CITY OF PORTLAND, MAINE
PLANNING BOARD

Project Name: The Forefront at Thompson's Point Project Level III Site Plan and Subdivision Application

ID: 2015-133 & 2015-159

PLANNING BOARD REPORT PORTLAND, MAINE

**WB-67 OVERALL ACCESS
ROUTE AUTO TURN
SIMULATION**

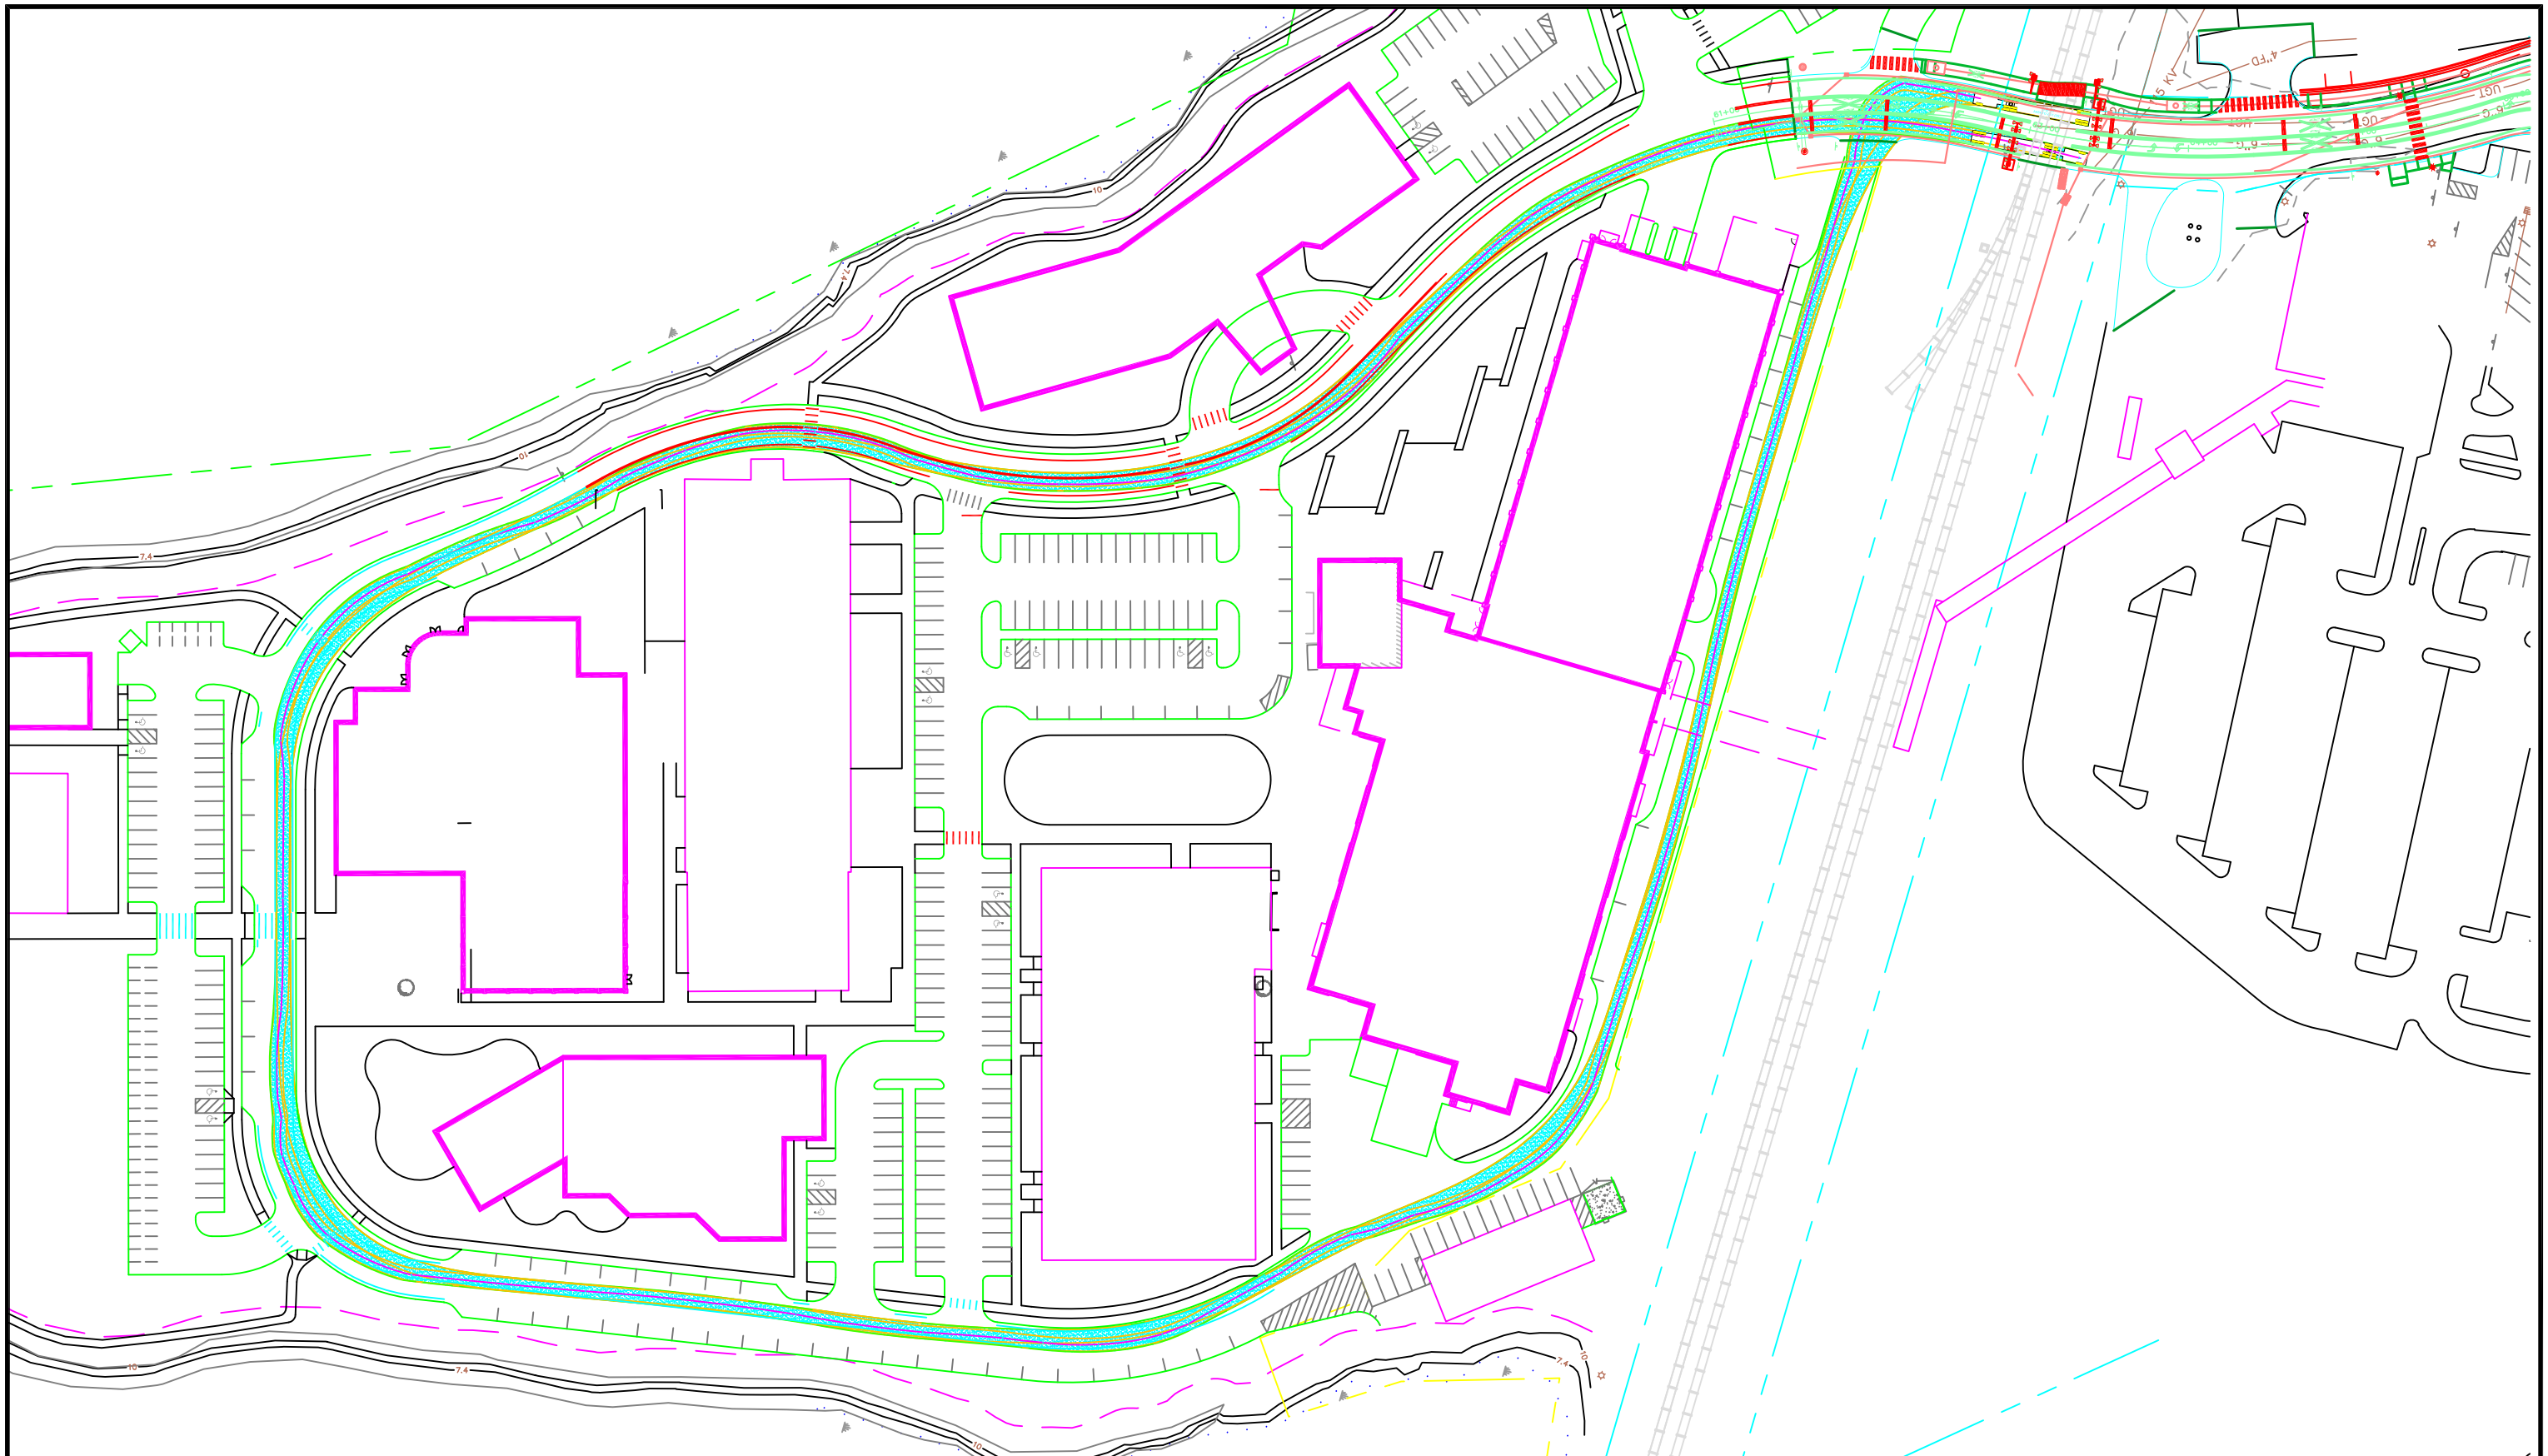
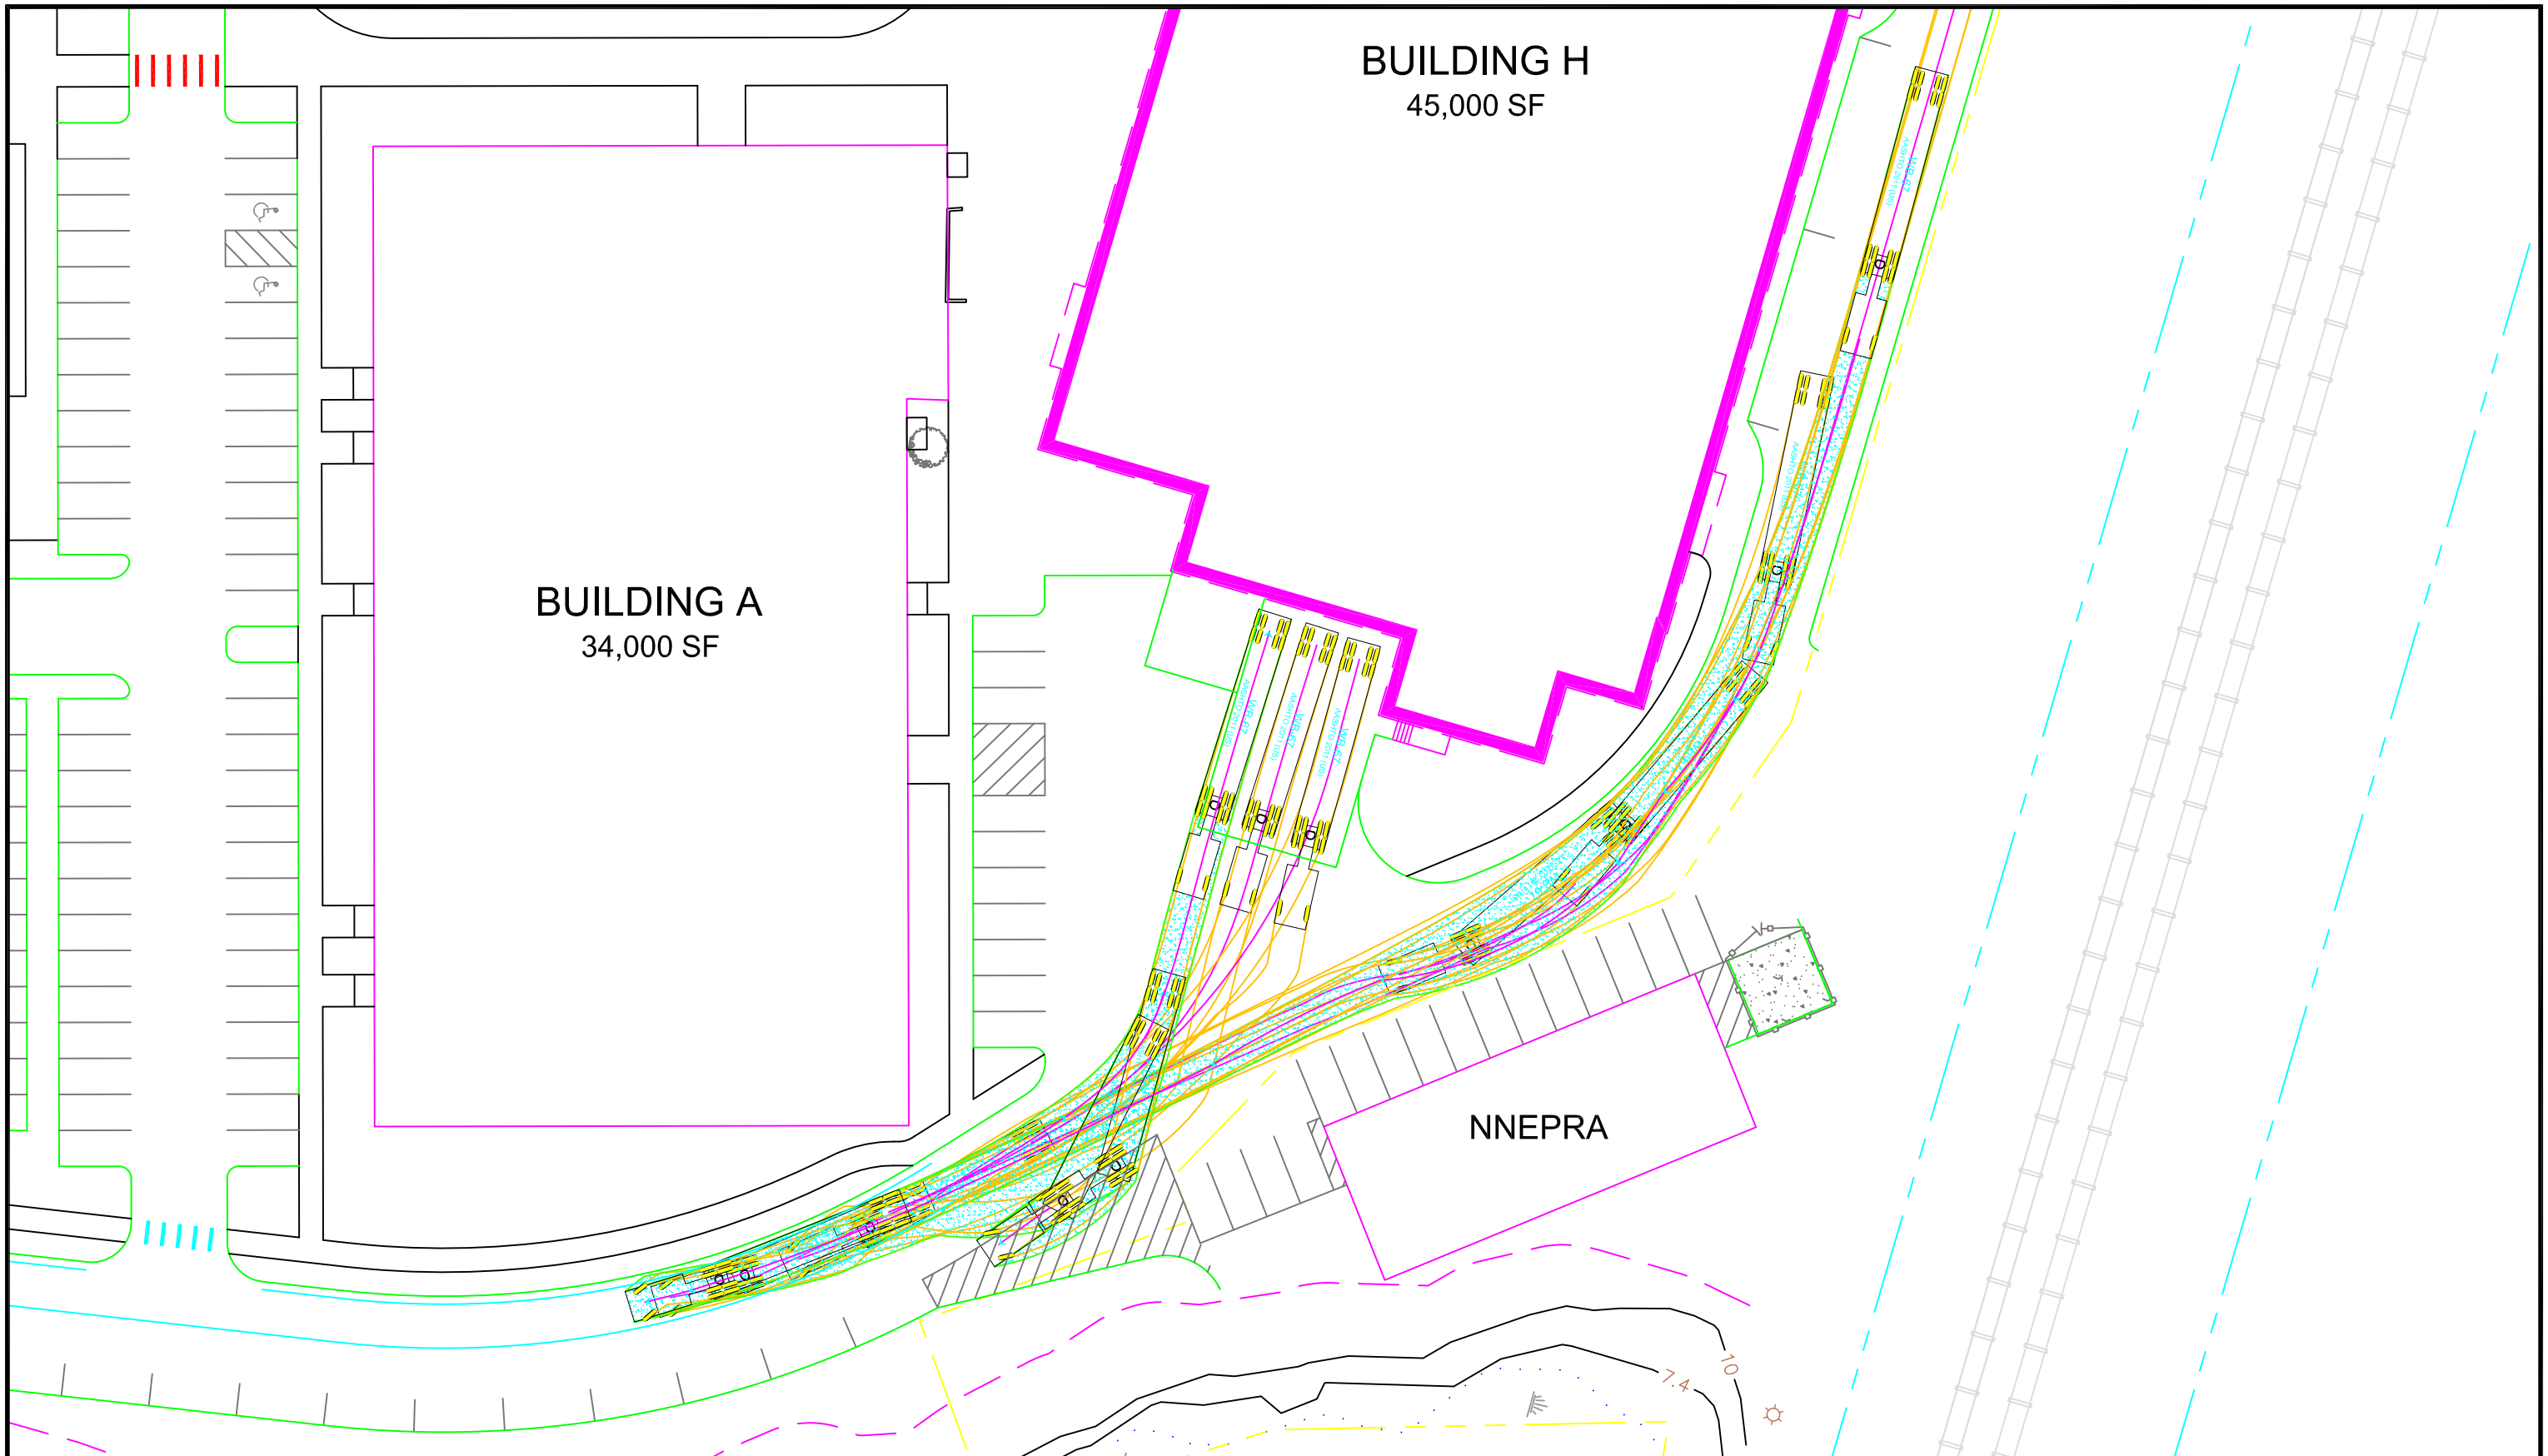
2. 1.7.2.9, requiring that vehicular circulation to be contained off-site and to not utilize the adjacent street system, to allow for anticipated delivery truck maneuvers.
